Our Ref: EP/62/20/DOC

Approval of details reserved by condition imposed under ref EP/179/18/PL relating to Condition Nos 3 - surface water drainage, 4 - visibility splays, 5 - car parking & turning arrangements, 6 - covered & secure cycle parking, 7 - materials & finishes, 8 - hard & soft landscaping and 10 - existing wall to south

Gladwyn The Street East Preston BN16 1HT

Scales: 1:50 1:200
No: 2386/01/12

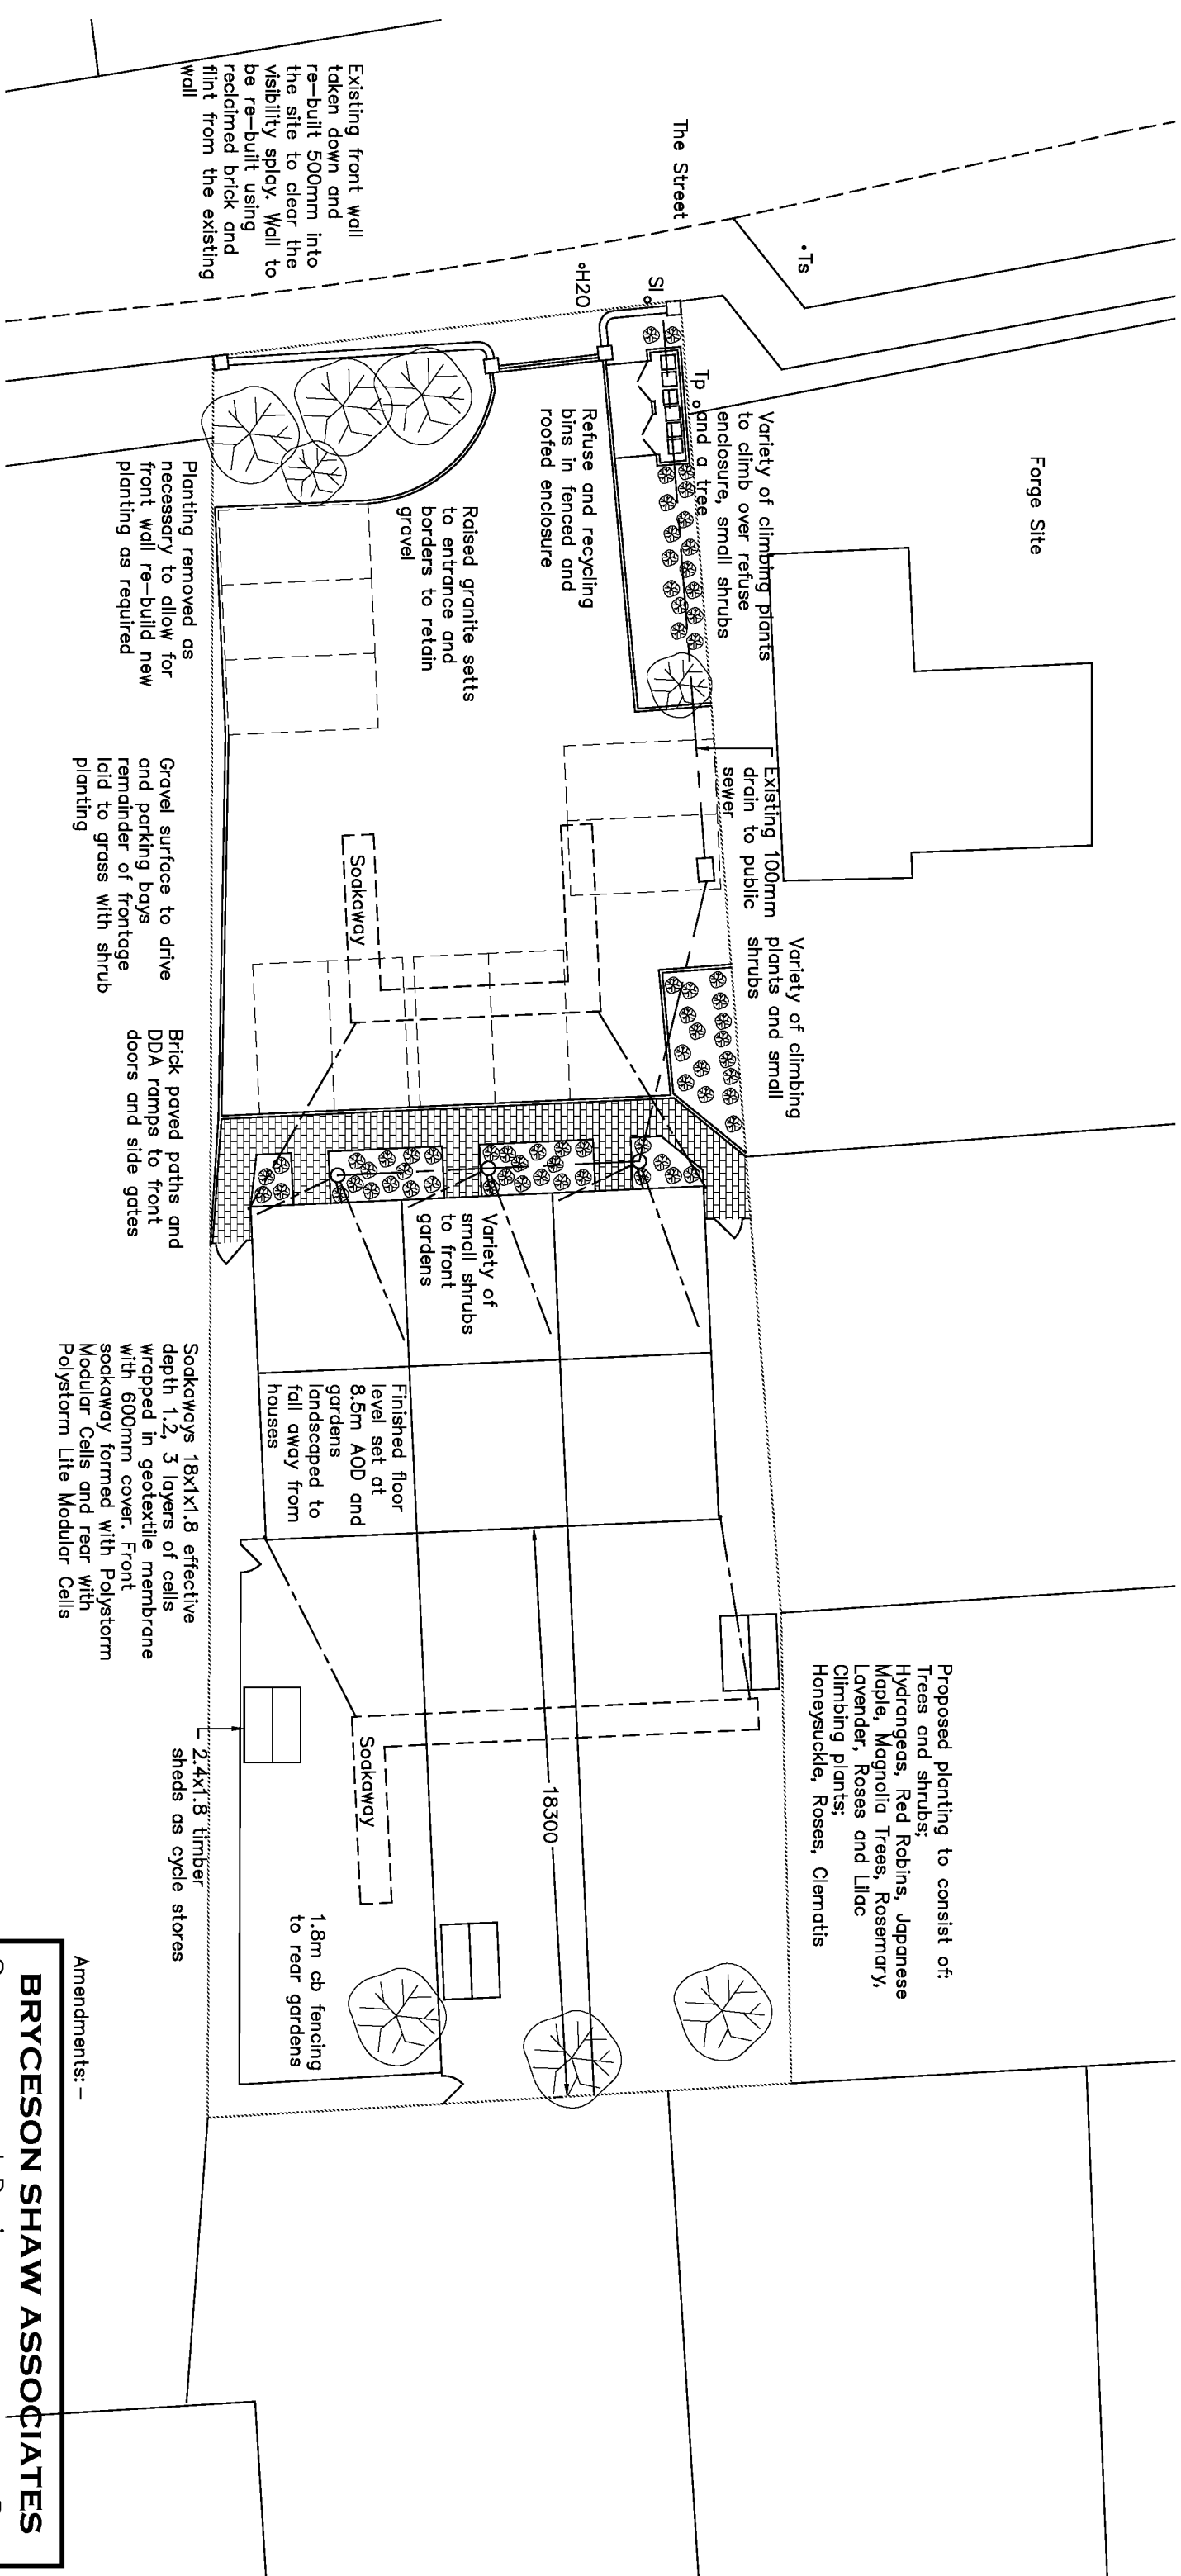
This condition is discharged in so far as submission of details relates and refers to the provision of garden sheds measuring 2.4m x 1.8m for secure and covered cycle storage indicated on the Landscaping and External Works Plan 2386/01/12.
